From: [Matthew Rooke](#)
To: [Norfolk Boreas](#)
Subject: EN010087 - Norfolk Boreas - Response to Examining Authorities fifth round of questions
Date: 04 September 2020 17:27:12

Apologies for the delay in responding on behalf of Broadland District Council but I have just returned from leave and unfortunately it was not possible to meet the stated deadline. I would be grateful if the Examining Authority accepts these comments in the circumstances.

13 APPENDIX 6 SCHEME OF HIGHWAY MITIGATION (B1145, CAWSTON)

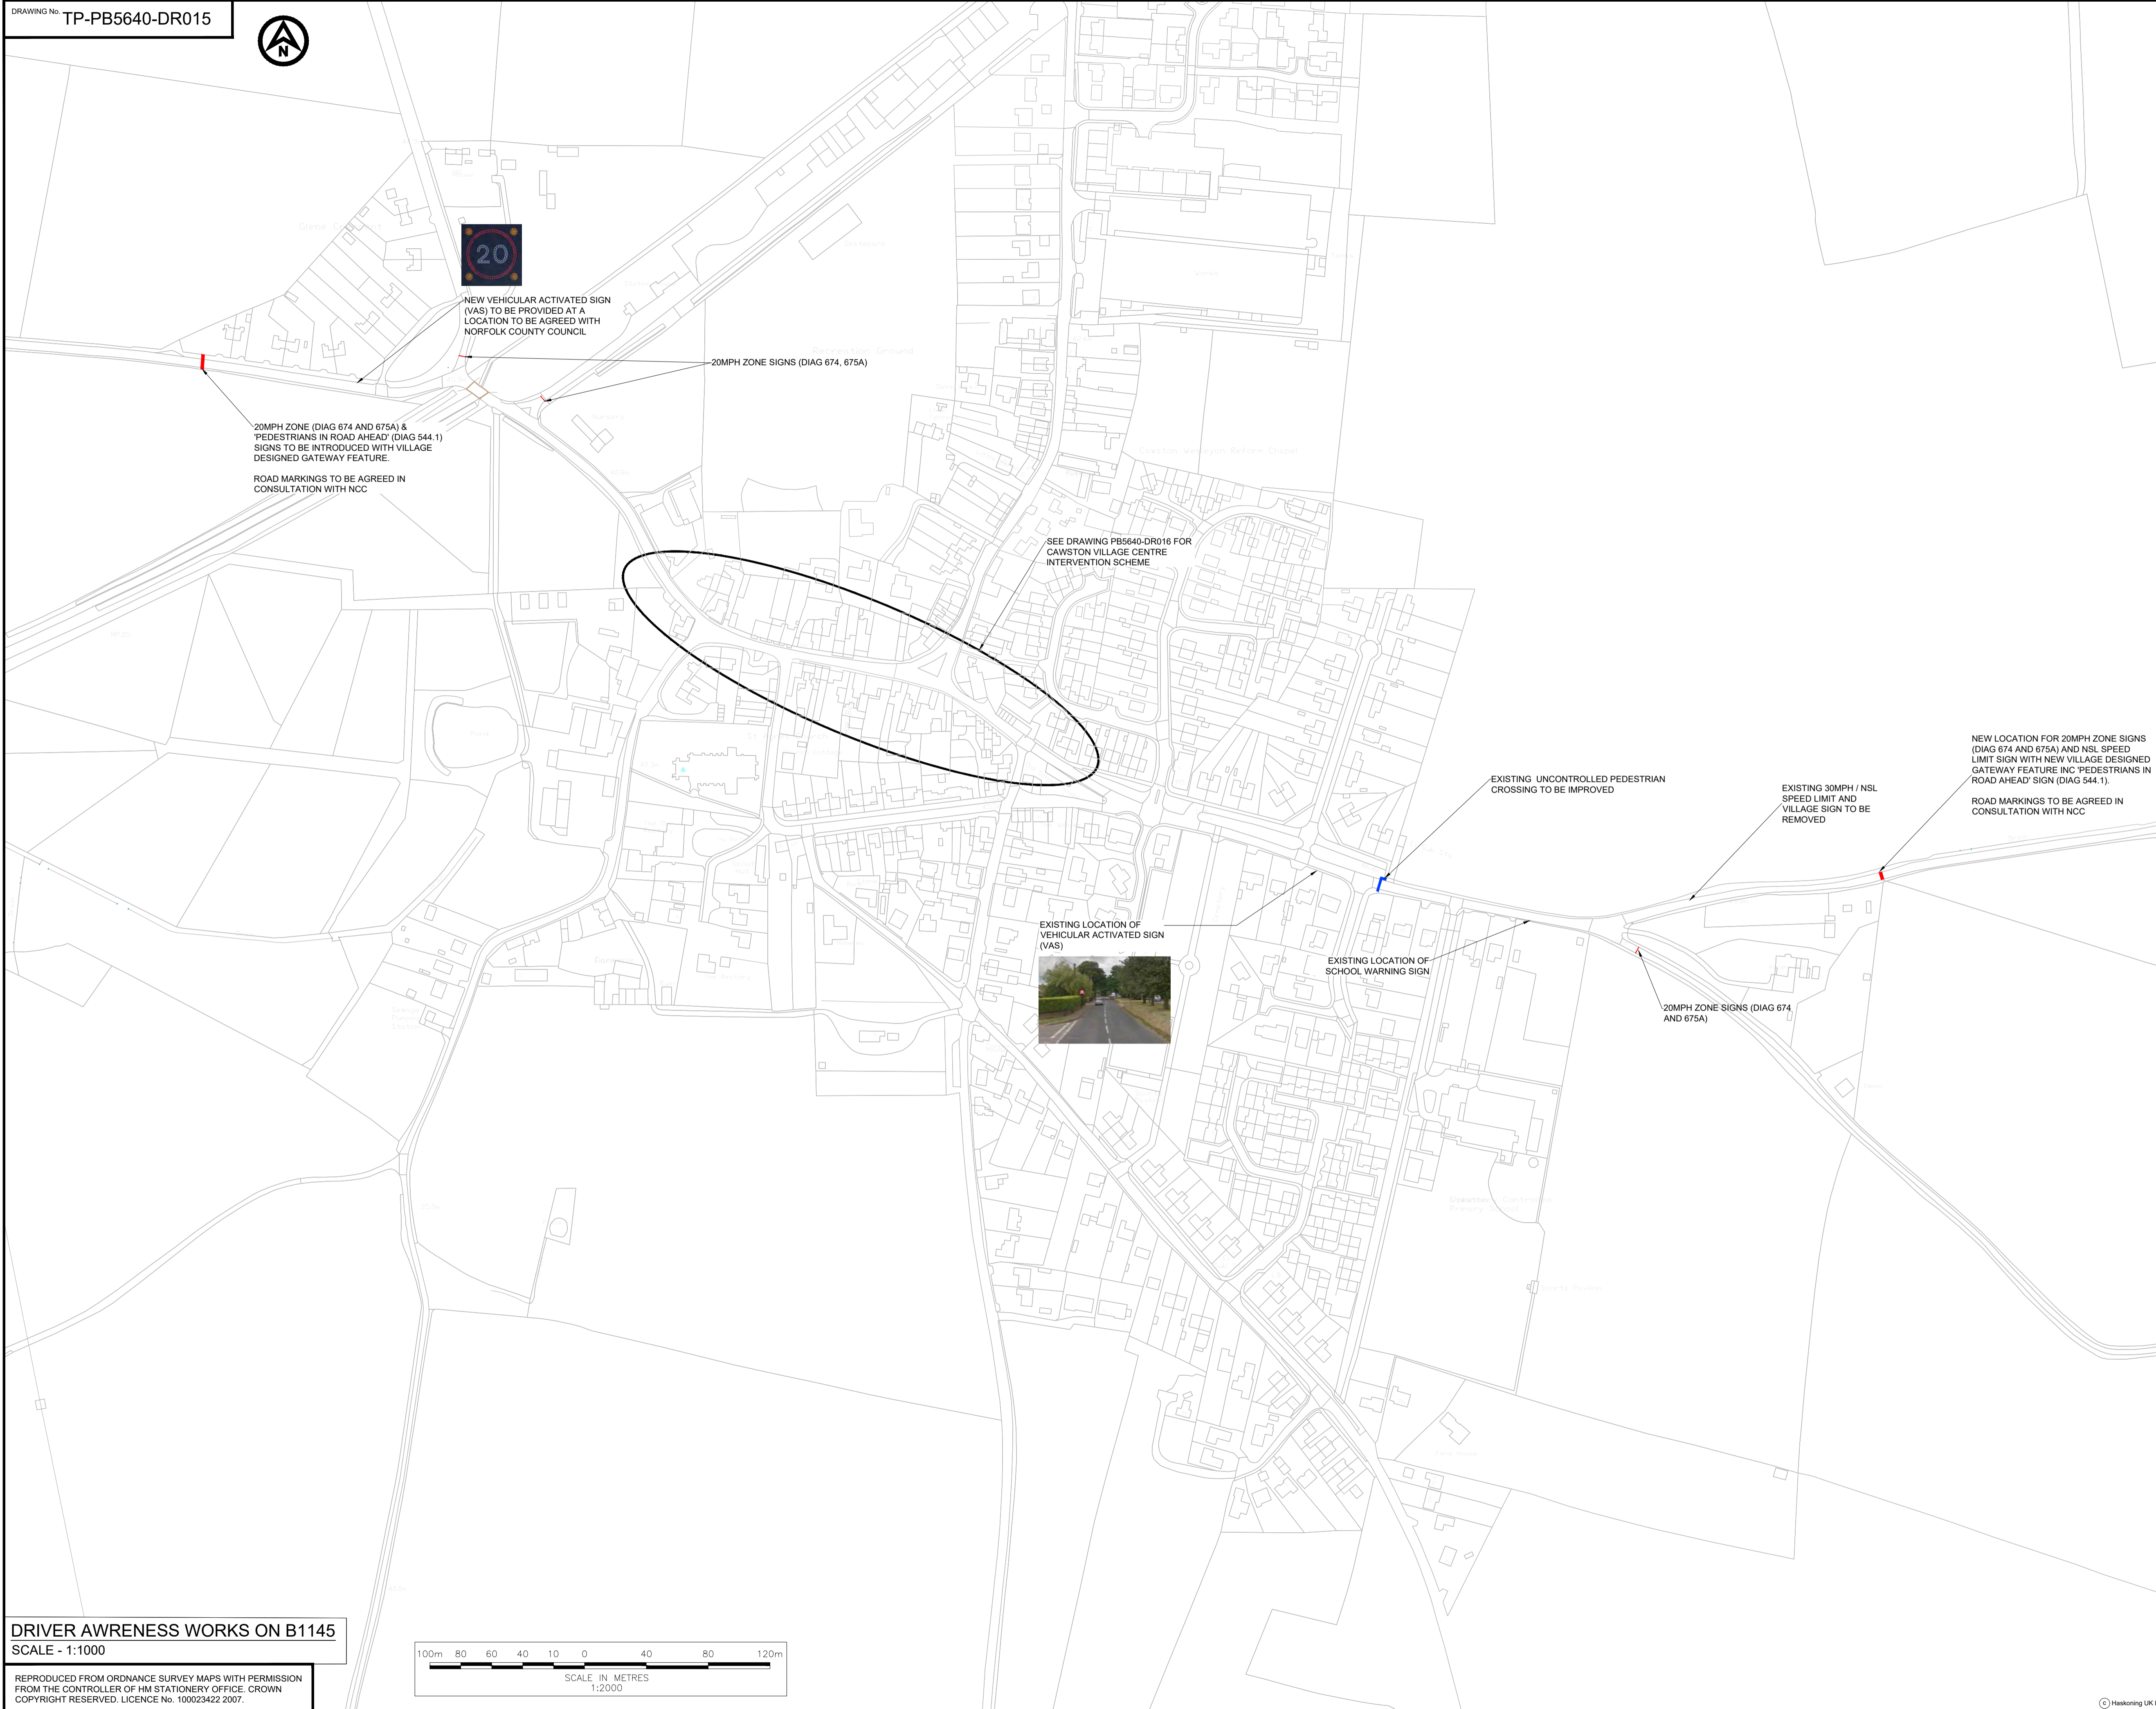
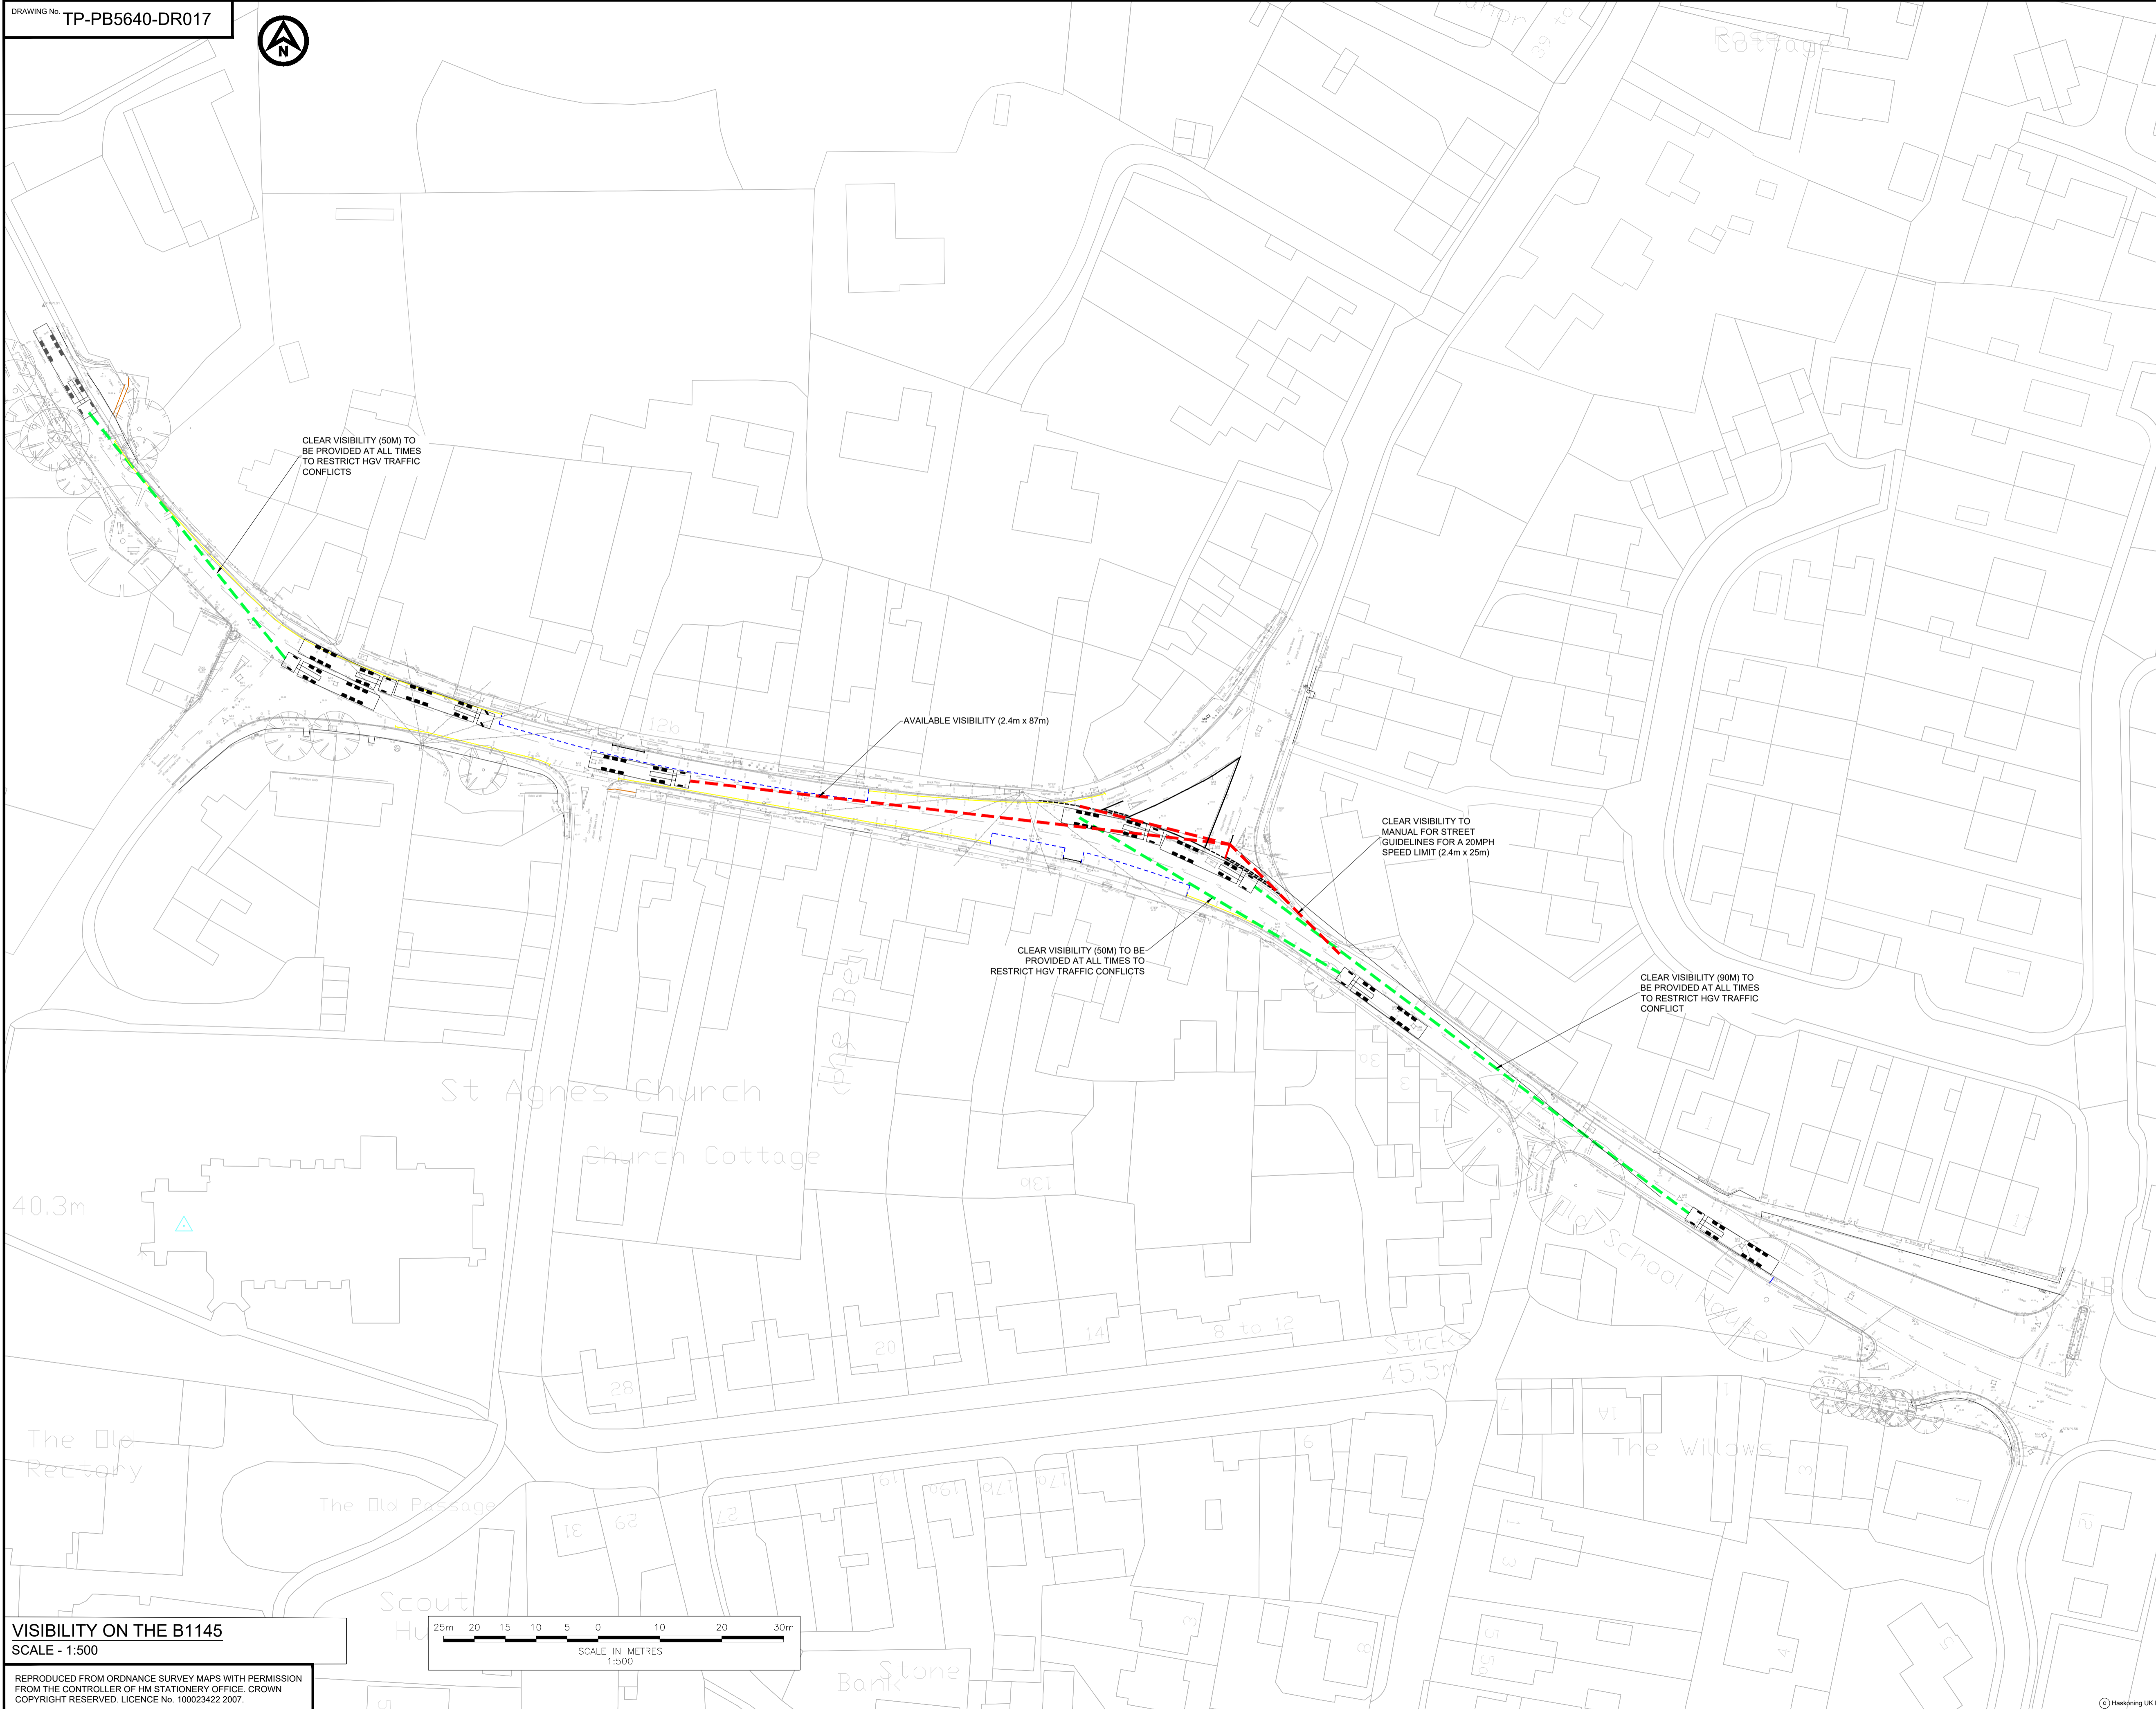
Q5.14.1.1 – Outstanding concerns from Cawston Parish Council – d) The District Council notes that the HIS for Link 34 has passed its safety audit as it is technically acceptable however the District Council is concerned that the increased cumulative traffic movements in the centre of Cawston will not function as effectively as the theory may indicate due to motorists non-compliance with the scheme and the adverse implications this will have for residents and other road users in the centre of Cawston.
